Our ref: R1742D-L20190218
Your ref:

20 February 2019

**Upper Heyford – Trenchard Circle (Planning Ref. 16/00196/F)
Verification Report Review & Gap Analysis**

AAE Remediation Excavation & Backfill Area

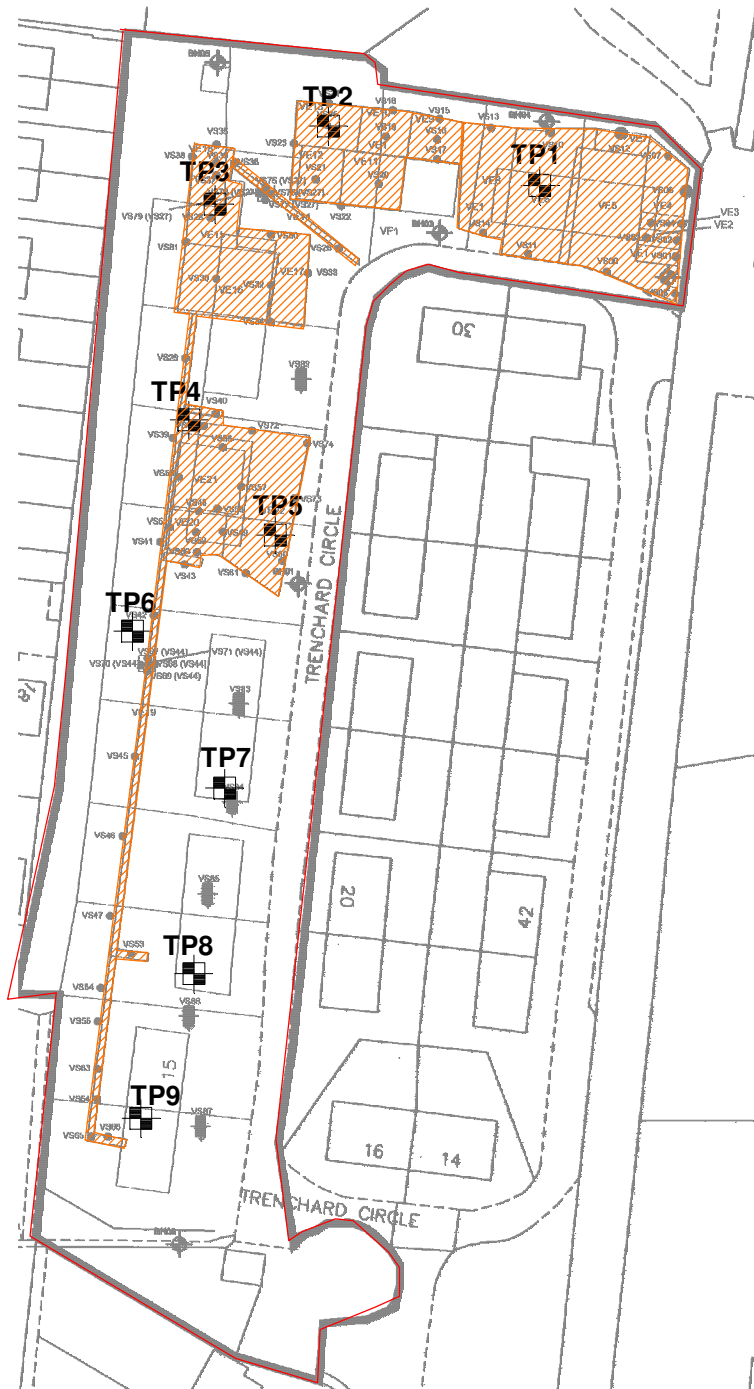
The relict pipework and grossly impacted soils were removed, and validation samples were collected, it is noted that no samples were collected from the base where bedrock was present. A series of rectangular validation excavations (VE1 – VE22) or remediation cells were excavated due to shallow groundwater ingress, groundwater in the excavations was pumped into a treatment plant before discharge to ground on the wider site. No information pertaining to the type of treatment or sampling of treated waters prior to discharge is provided. In addition to the validation excavations, 6 trial-pits were excavated outside the remedial excavations to confirm the absence of contamination.

Following removal of visually impacted soils and collection of validation samples, ORC was placed in the base of the excavations and the voids were backfilled with suitable fill material. No information is provided on the source or origin of the material although it is stated that verification of backfill material used will be reported under a separate cover. It is uncertain whether this has been reported.

These works have not been completed in the existing validation reporting and are to be completed and reported in accordance with the SGP Strategy unless a 600mm soil cover of clean validated soils is placed over existing site soils.

It is a requirement under the SGP Strategy that validation of backfill material following tank / contamination removal etc. is verified to comply suitability for reuse. Testing is to comply with the criteria outlined in Table 6.3 of the SGP Strategy. Validation of the backfill could be satisfied by completion of the validation of formation soils (point 1) provided these areas targeted for sampling.

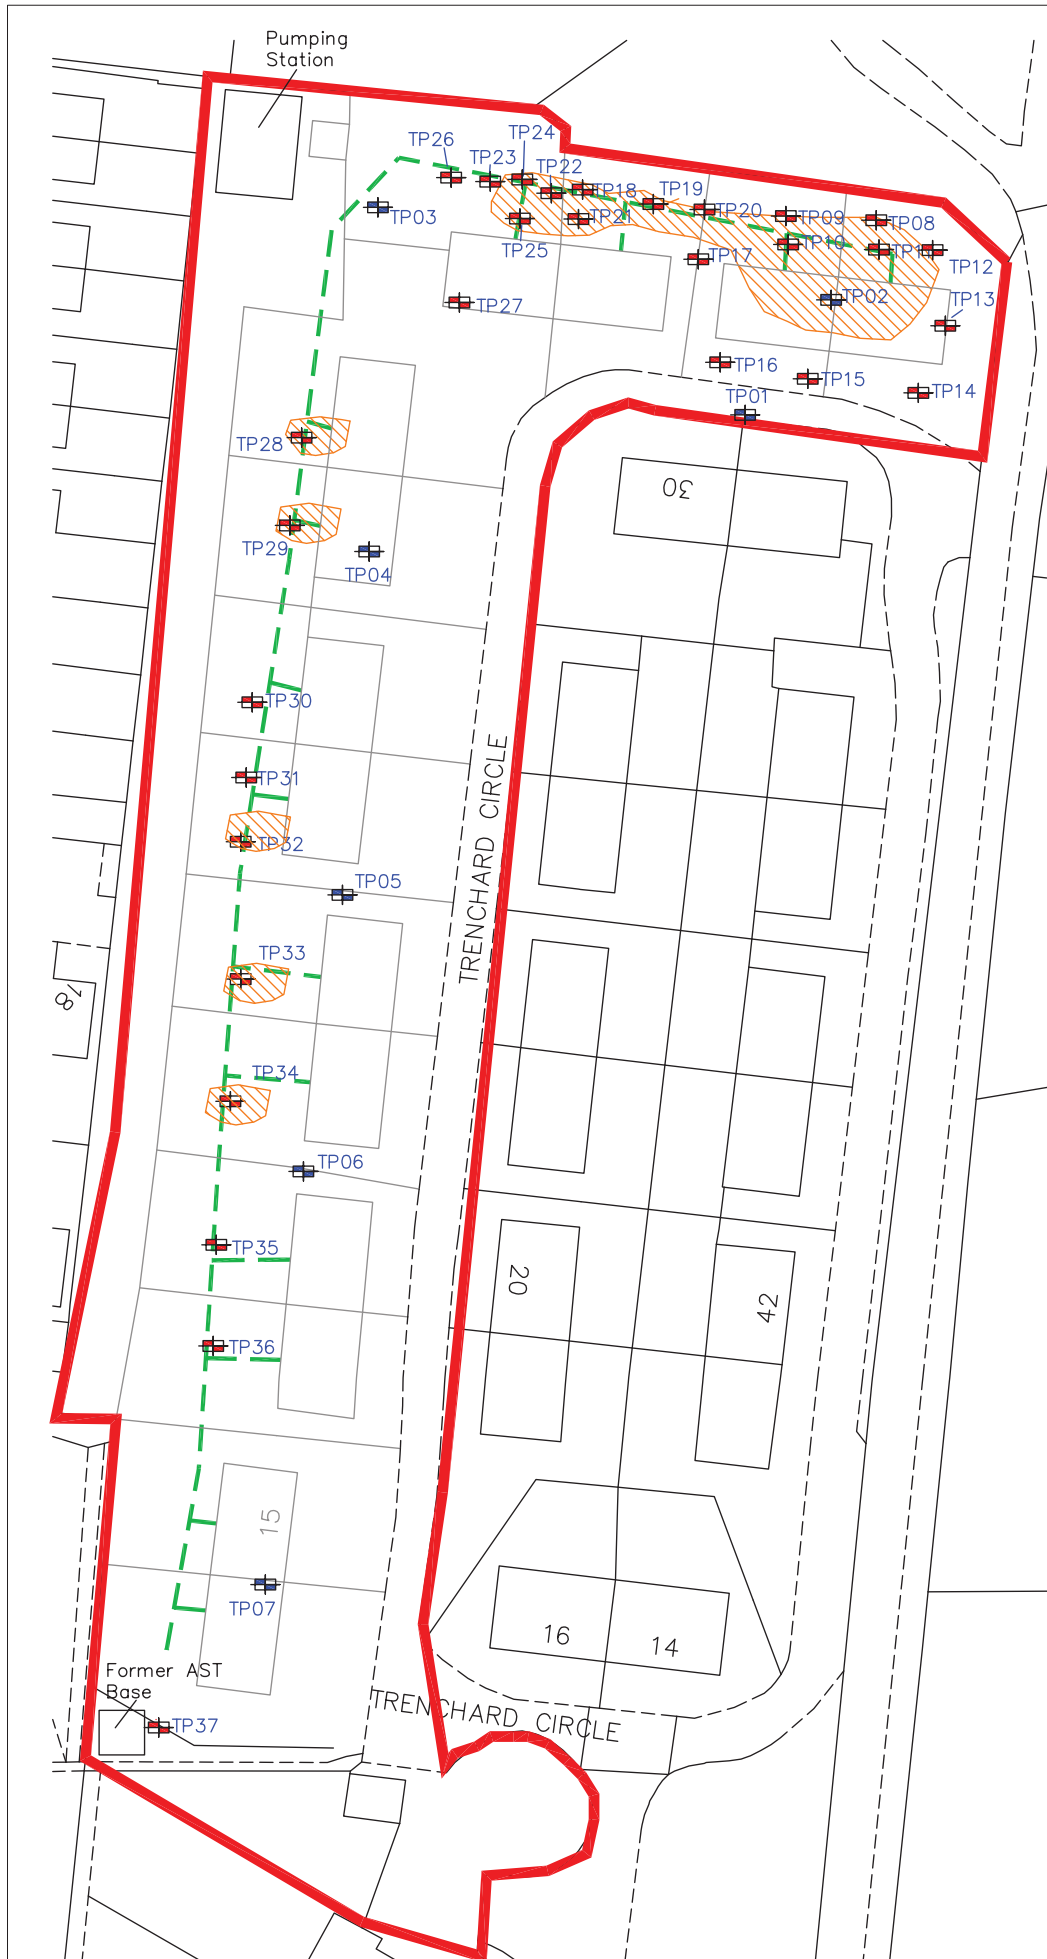
Contamination indicators including staining and hydrocarbon odours were observed with a maximum PID reading of 132.3 ppm (TP18 0.9m bgl) and were associated with the oil pipe (consisting of 2 metal pipes) which remained in-situ. It was observed that the pipe lines connected to the former properties via feeder lines. No contamination indicators were recorded outside the area of the oil pipeline.
